From: Jenny Preager [REDACTED]
Sent: 22 February 2018 18:33
To: Planning
Subject: Ref: A/8/18/PL, FAO Mrs A. Gardner

I strongly object to planning application A/8/18/PL being approved.

Ground Floor Plan @ 1:100

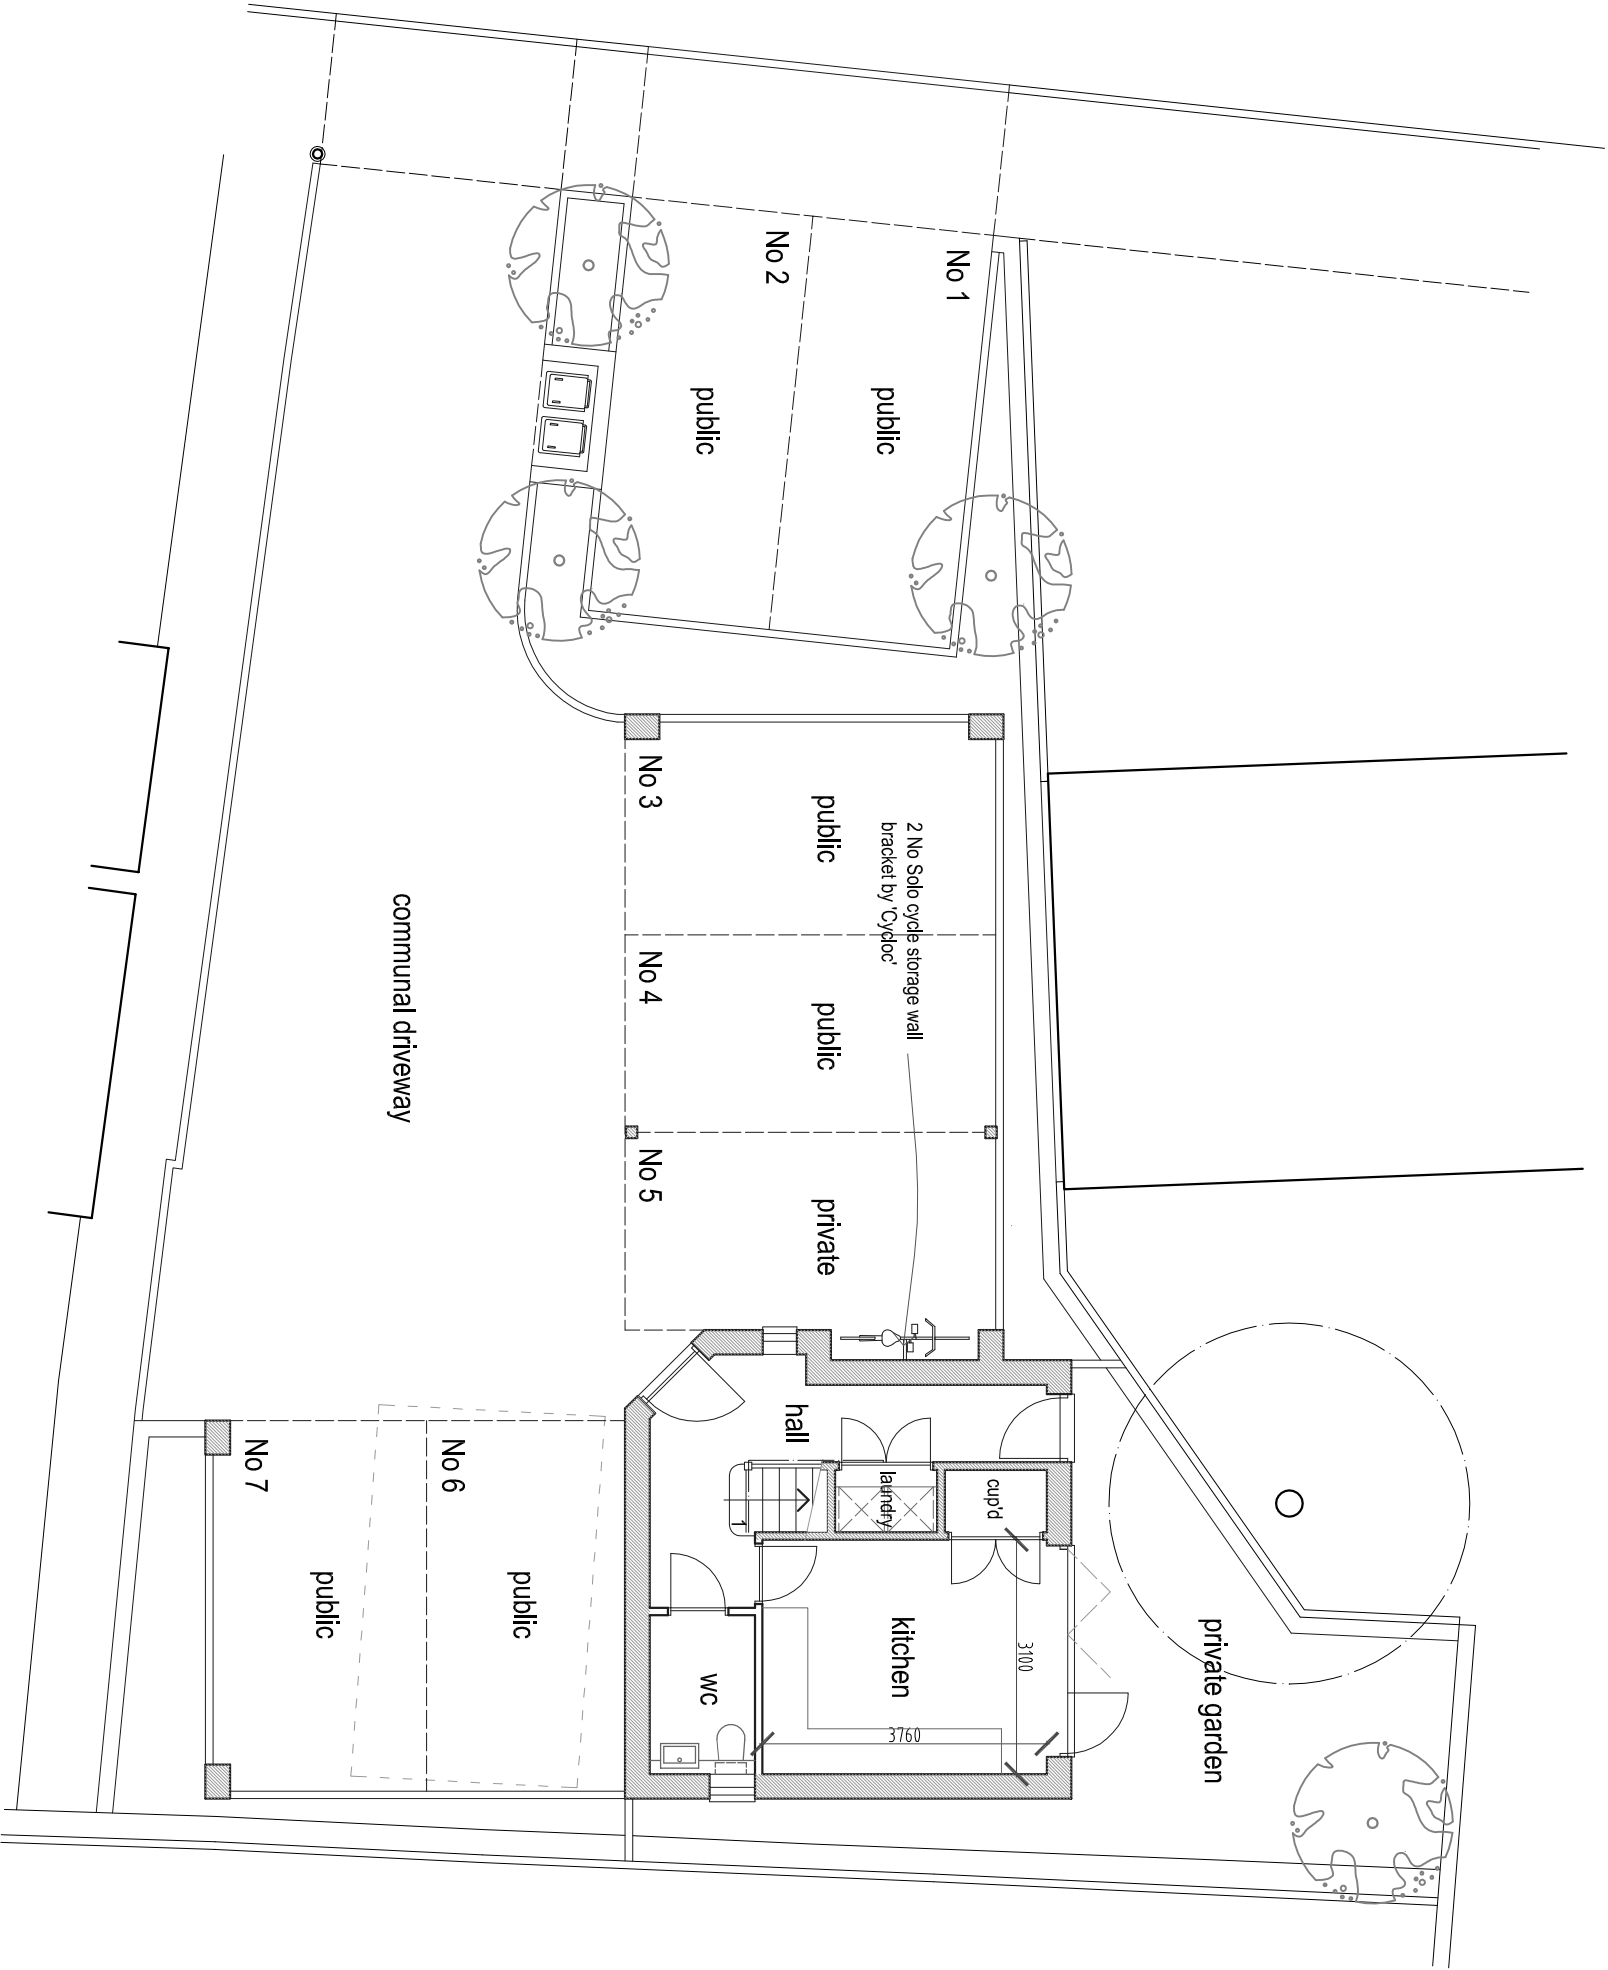
The building encroaches on the right of access alleyway behind 1-6, therefore the wall of the property is outside the plot boundary, it is also built right up to a drain cover, the concrete shoulder of which has been destroyed to allow space for this.

Rev	Description	Date
Job Reference New House The Cottrells Angmering, BN16 4AF		
Client AM Homes Ltd		
Drawing Title First Floor Plan & Roof Plan		Drawing No ADC962/13
Date 16.01.18	Scale 1:100	Dwg Size A3
		Plot Style ADgrey.spl
		Drawn AD
		Checked AD

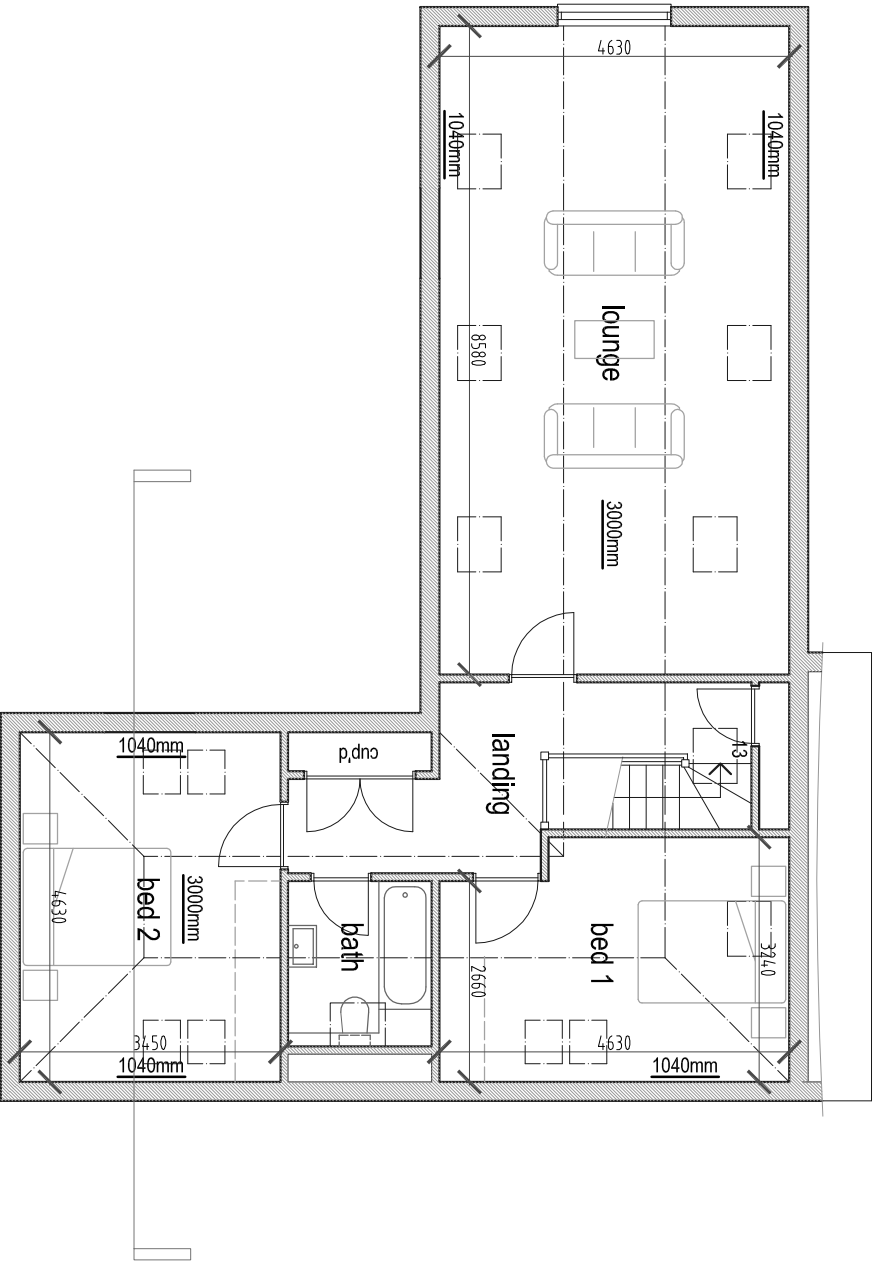
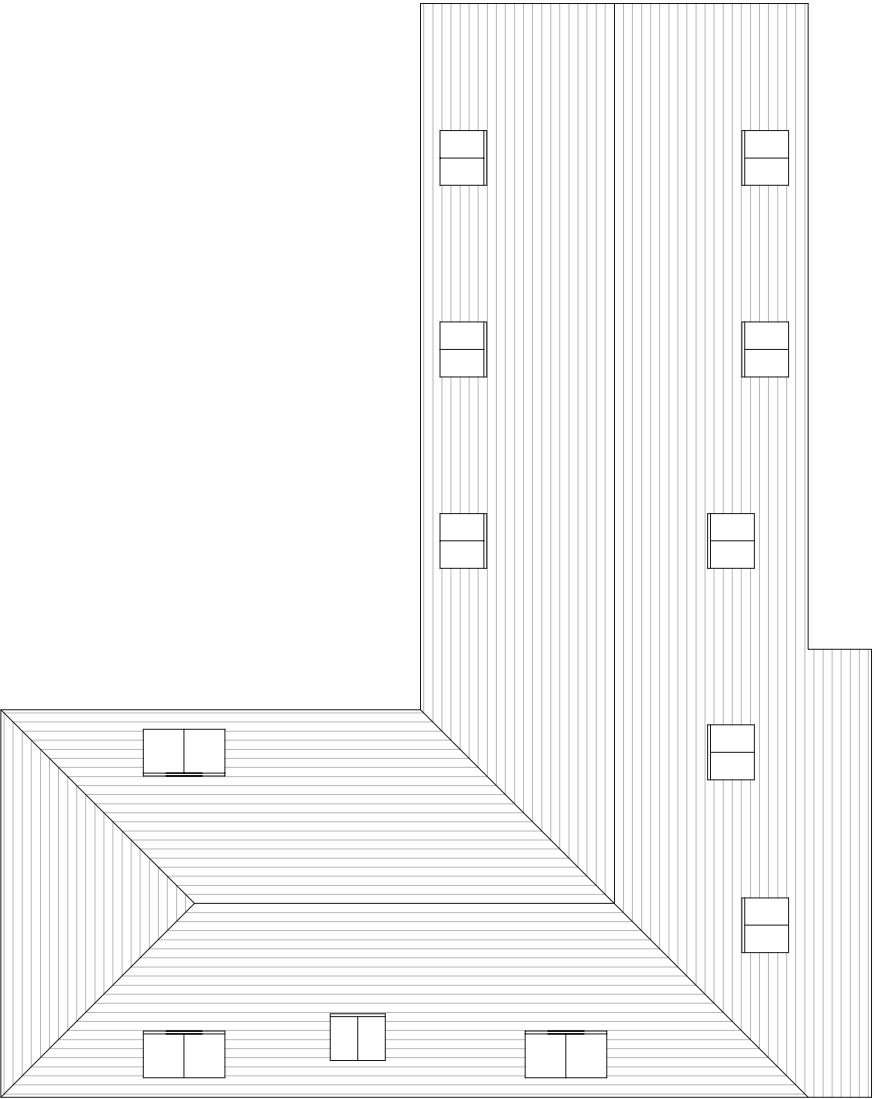
It seems that the interior layout has been planned and built to allow for a third bedroom, permission for which has not been granted.

Side (South) Elevation @ 1:100

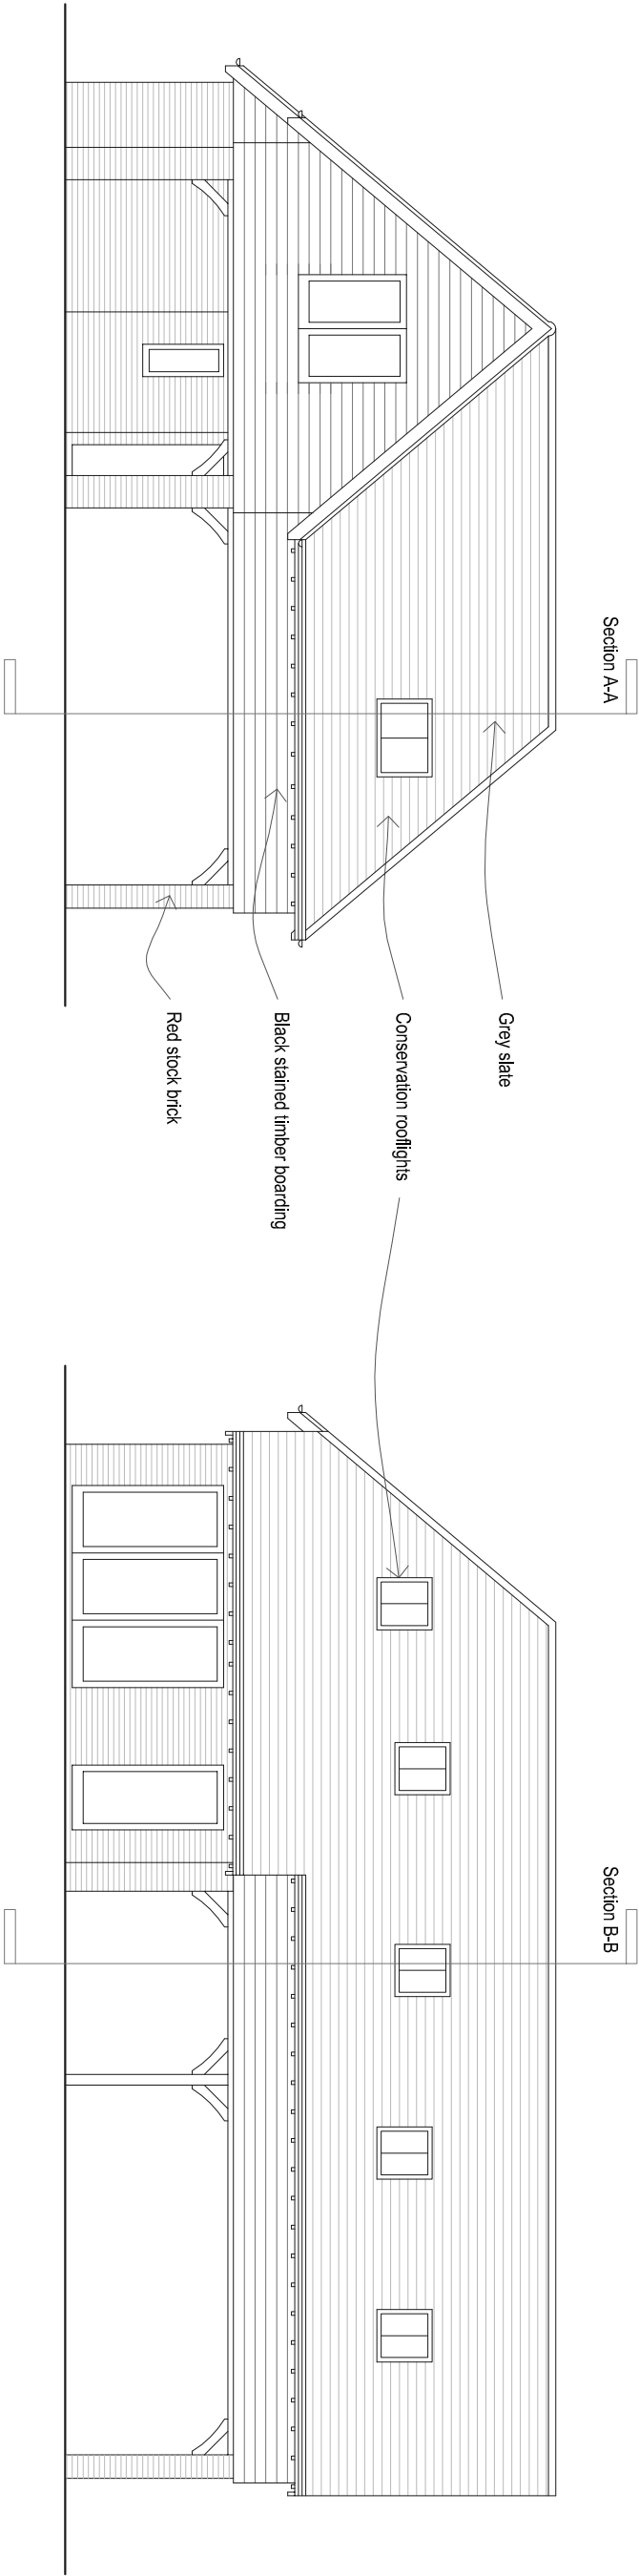
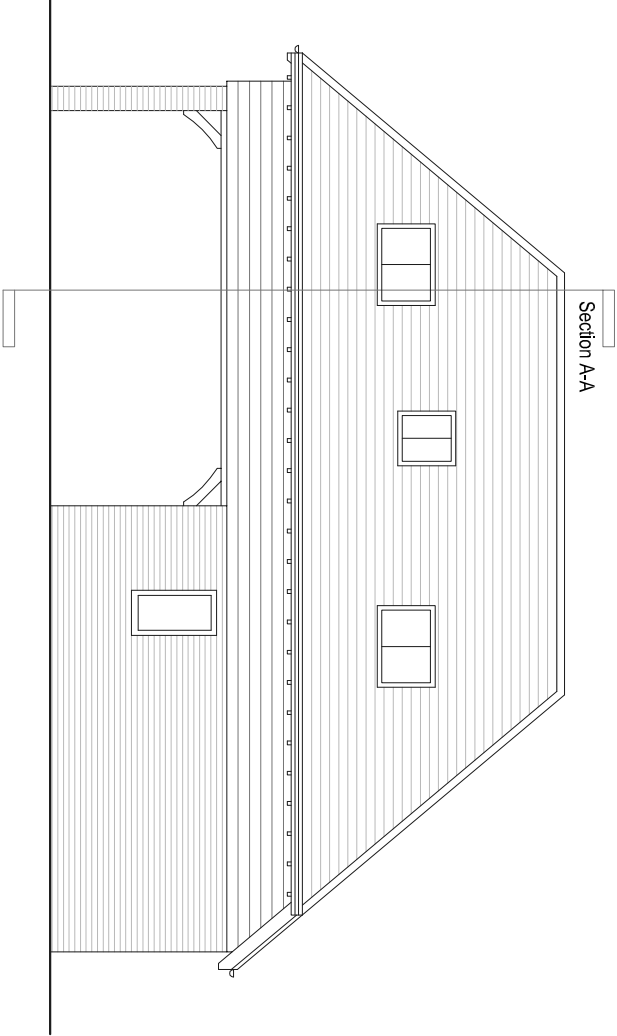
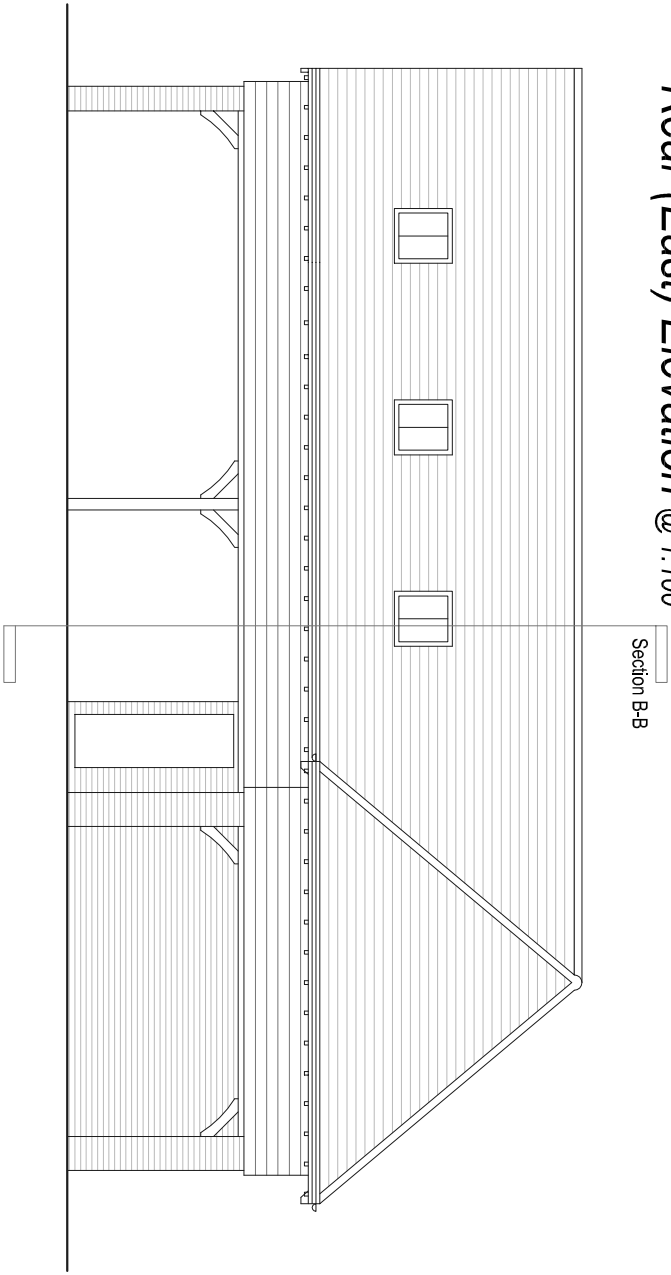
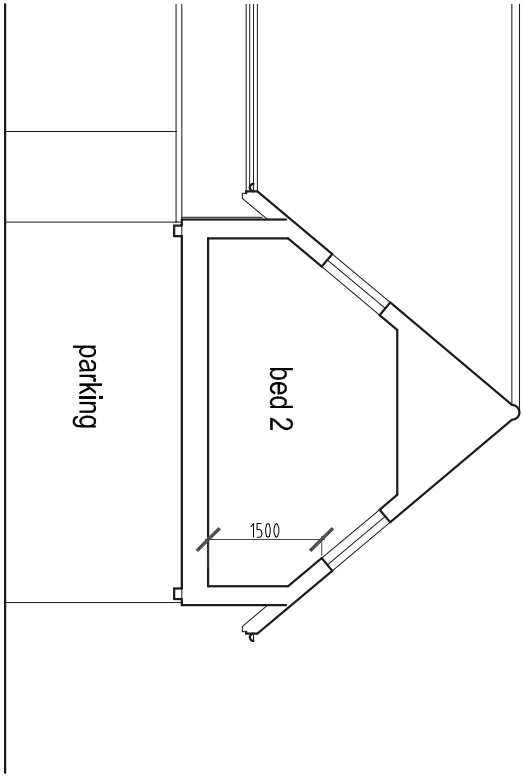
The constructed roof line on the south elevation differs from the approved plans being a barn end instead of the approved hip end. This results in the houses and gardens of houses 1-6 being even more overlooked. It also results in the development becoming even more intrusive and at odds with the surrounding conservation area.
